# Monte Scientia Project

## Heritage Response to Submissions – SSD10393

This report has been prepared to address heritage related concerns raised by the Department of Planning, Industry and Environment (DPIE) and North Sydney Council in response to a State Significant Development application for the Monte Scientia Project, at Monte Sant Angelo Mercy College, North Sydney.

Figure 8 Façade Refinement

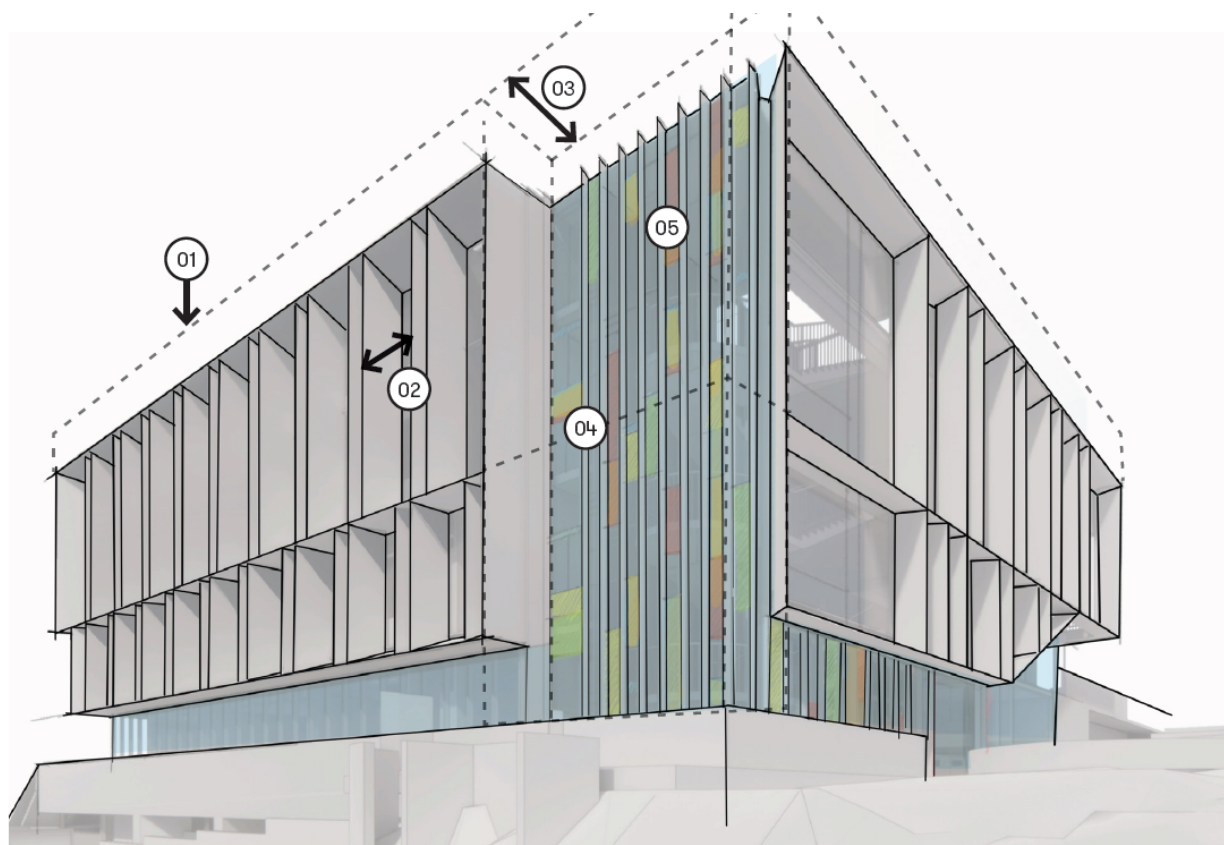
*It is recommended that the form of the proposed building be further articulated and that a greater vertical emphasis be placed on the buildings massing, not just the façade treatment. It is also recommended that some fine-grained detail be introduced such that the character of the new building does not overwhelm the character of the historic buildings.*

The recommendation to revisit the overall design of the building has been taken into consideration, and changes have been proposed. As recommended, the façade treatment has been refined to place a greater vertical emphasis on the façade elements and the general proportions of the various components. A major change is the addition of the 'corner lantern' which removes the projecting corner delineation of the earlier scheme; and is more recessive, and so sympathetic to the approach from Miller Street where the building is viewed adjacent the Chapel building from the entry driveway.

Figure 12 Key Impact of Setback Increase

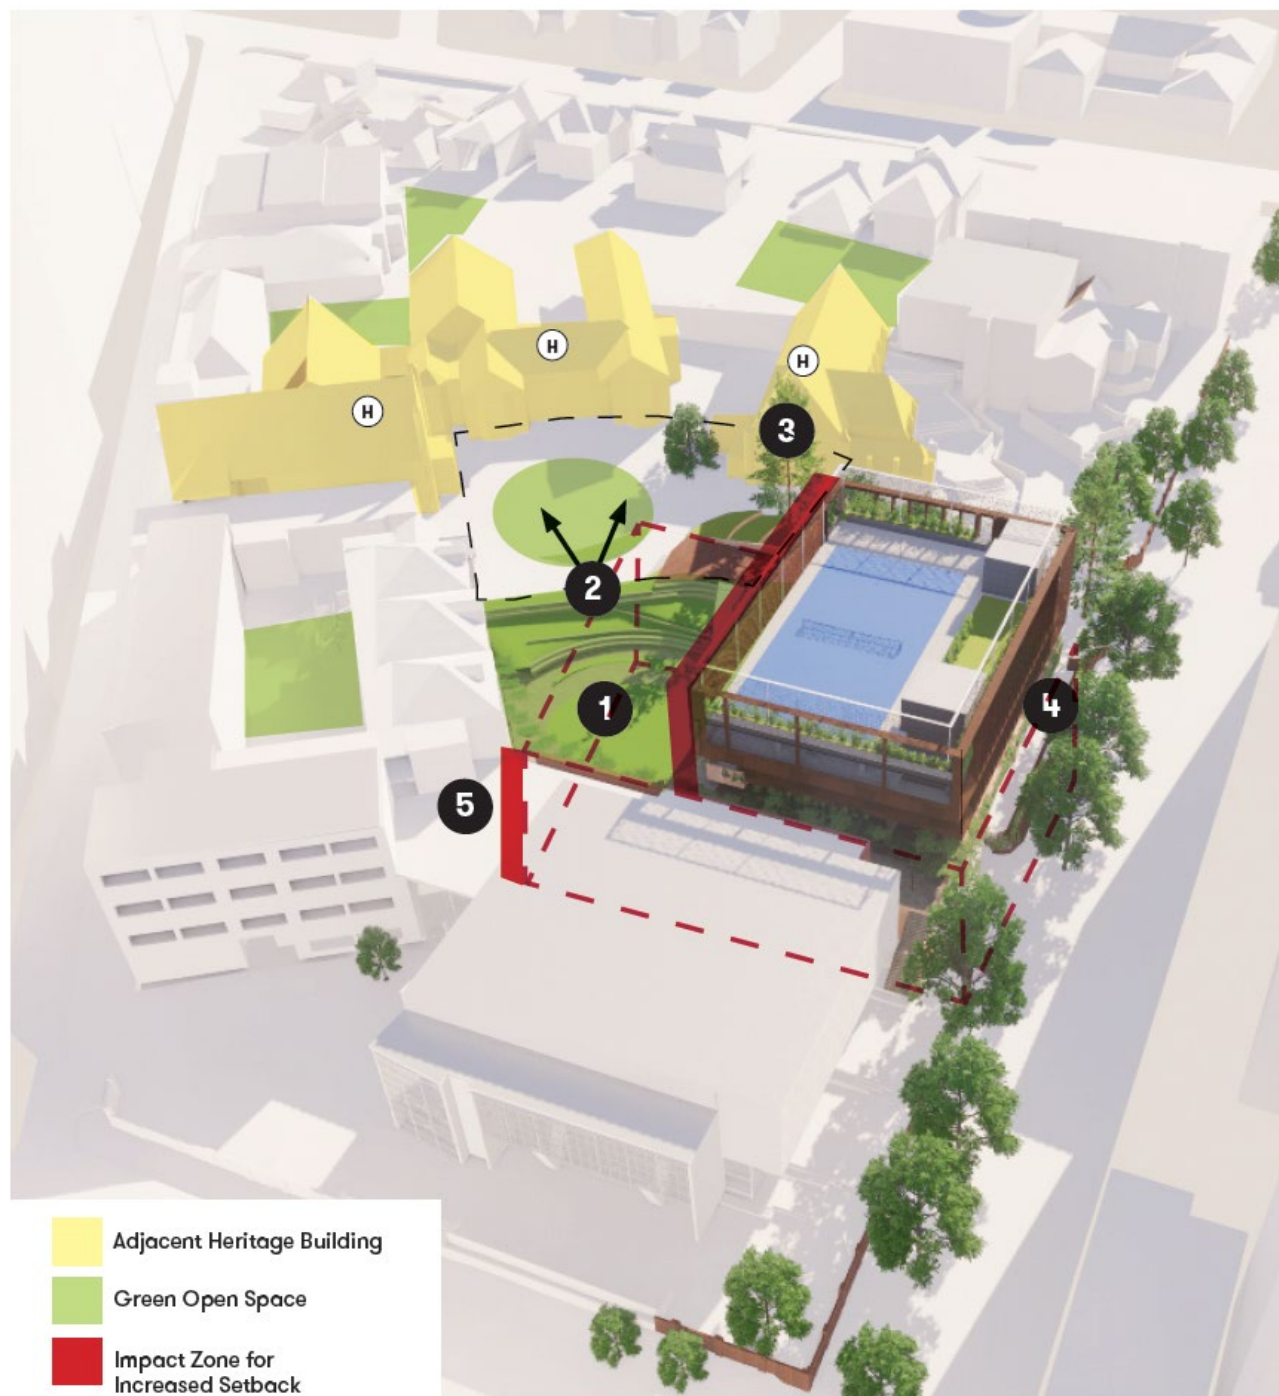
*It is recommended that the setback along Miller Street match that of the McQuoin Centre and that a deep soil planted buffer zone of trees is provided behind the Miller Street heritage wall.*

Alteration of the proposed building setback along Miller Street to coincide with the McQuoin Centre was considered, however the existing site relationships and the requirements of the new building meant that this amendment was unfeasible for the following design reasons.

The overall driver for the size of the proposed building has been dictated by the standard dimensions of the rooftop sports courts.

Pushing back the building from Miller Street would result in excavation works having an adversely impact on the structural stability of existing buildings to the west.

Space lost from the increased setback would narrow the central courtyard and diminish its relationship with The Holy Grass. This action would also reduce views towards the heritage precinct from the courtyard, particularly to The Chapel.

The increased setback would naturally bring the new building closer to the heritage precinct, and so have a greater impact on the curtilage of the heritage items and the Holy Grass.

Figure 13 Street Wall Treatment Comparison

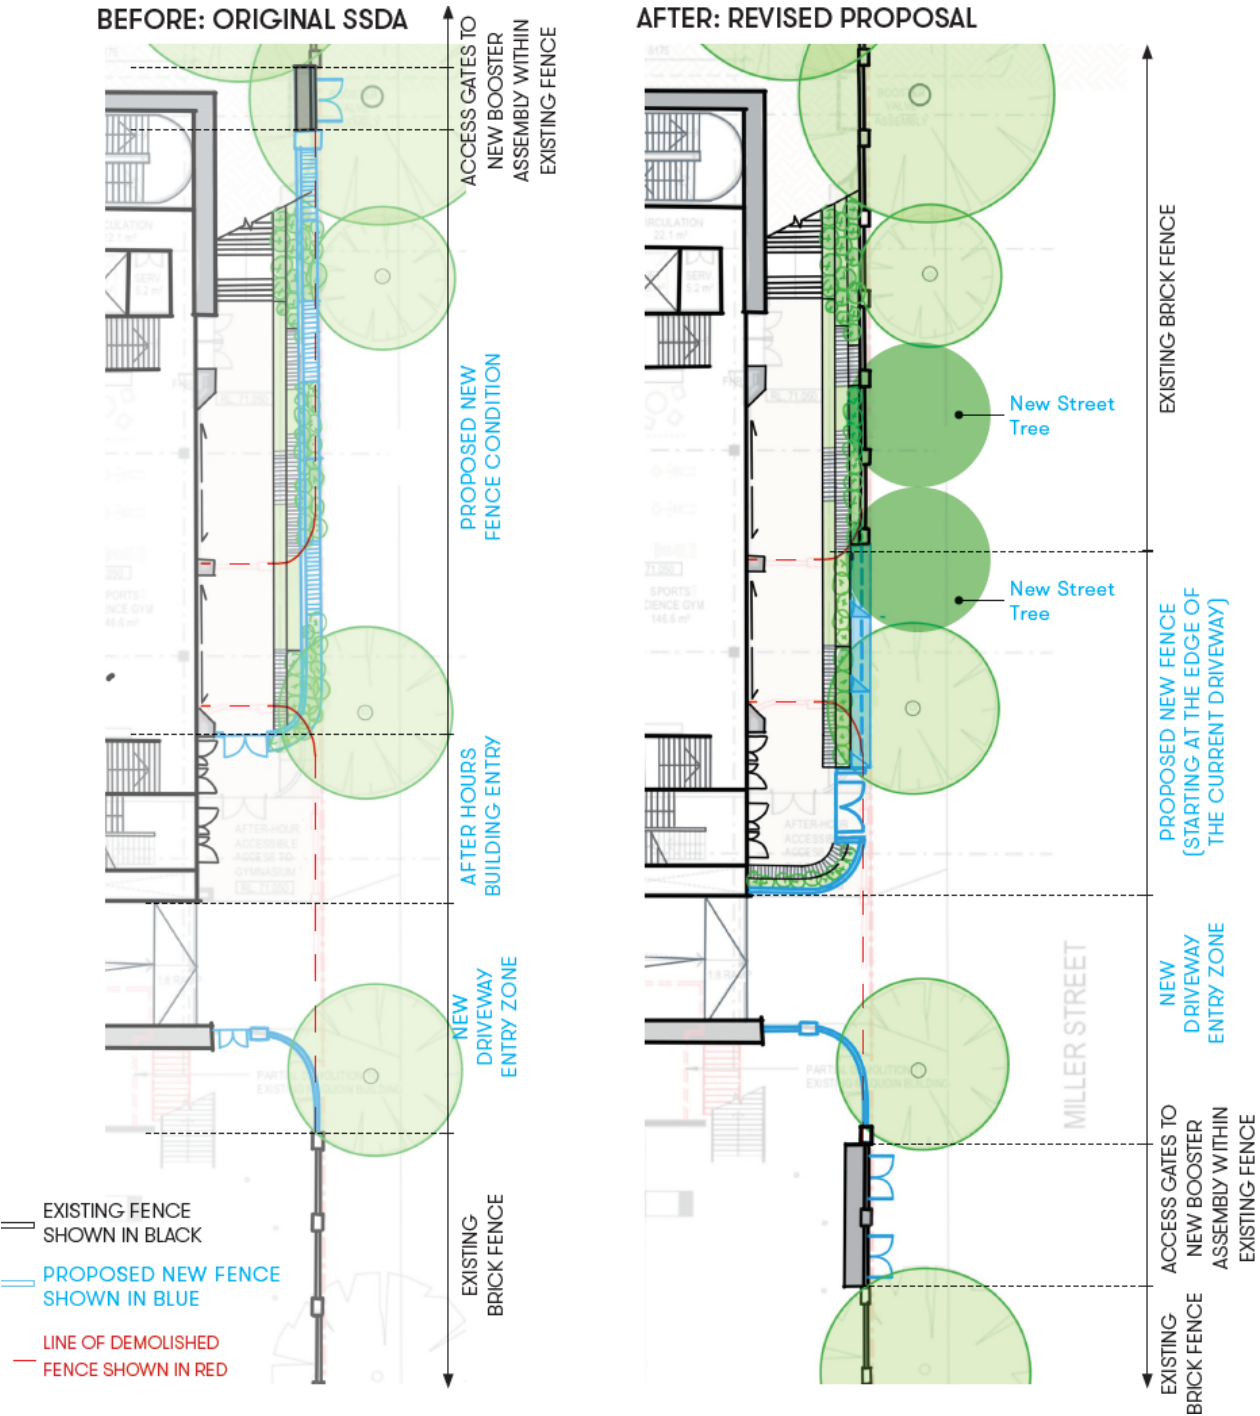
- *Demolition of Existing Miller Street Historic Wall – The existing wall contributes to the Catholic cultural history of the enclosed school site and also contributes to the Miller streetscape. It is noted on the site's Statement of Significance as being an item of heritage significance. Demolition of the wall is therefore not supported.*

*It is recommended that the proposal be redesigned to retain the existing wall.*

As recommended, the design of the proposed changes to the Miller Street wall has been revisited, resulting in the retention of a greater extent of existing wall fabric along with the refinement of the detailed design to those portions of the wall to be altered. The alterations to the wall are in response to the existing driveway entry being relocated further to the south; the resulting wall design is proposed to infill the current entry opening.

The new area of wall is required to infill where the existing vehicular entry is currently located, and so no wall currently exists. The primary amendment to the design of the fence involves the maintenance of the height of the wall as it steps up Miller Street. The original proposal for the new portion of wall was a low brick wall (note views 1 and 2 Before above) with open landscaping; the amended design continues a full height structure in line with the existing wall, articulated in bays to maintain the existing structural rhythm.

The requirement for light and street access to services, namely the hydrant booster valves, has been addressed through the insertion of metal screens, coloured to marry in with the wall and so maintain the visual definition of the site.
